Our Ref: ID 3326  
Your Ref: SSD-50725708

Jess Watson  
Department of Planning, Housing & Infrastructure  
Locked Bag 5022  
Parramatta NSW 2124

### **State Significant Development Application for Dinawan Wind Farm**

Dinawan Energy Hub  
Flood Study  
Figure A.2

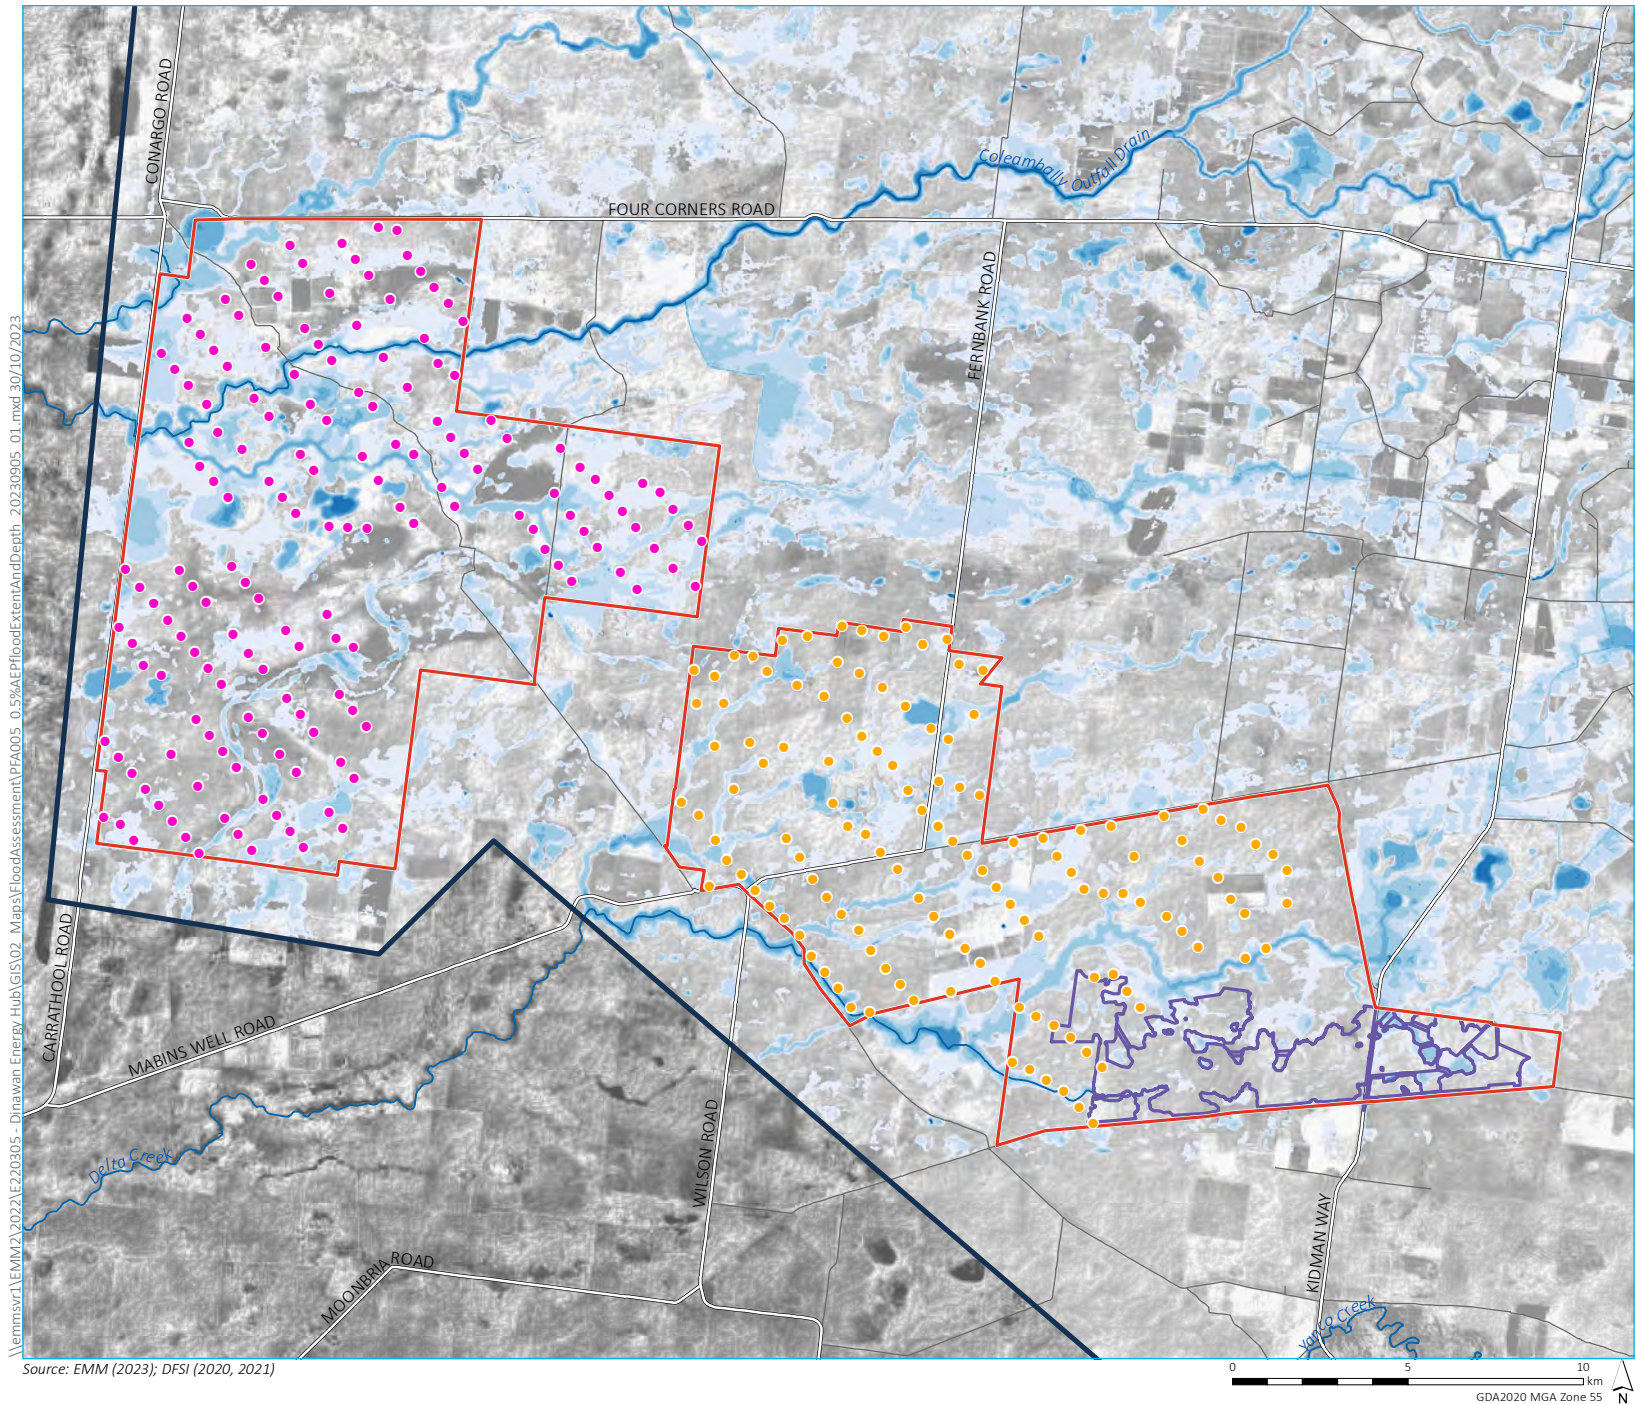
The site is traversed by a number of water courses<sup>6</sup> and is affected by flooding in the 1% Annual Exceedance Probability (AEP) event reaching depths in excess of 1 metre in isolated areas.<sup>7</sup> The areas surrounding the accommodation facilities are also identified as partially flood affected in the 1% AEP event to depths of up to 0.16 metres. During the Probable Maximum Flood (PMF) flooding in the area of the proposed accommodation reaches depths of 0.58 metres<sup>8</sup> and Hazard Level 3 (H3).<sup>9</sup>
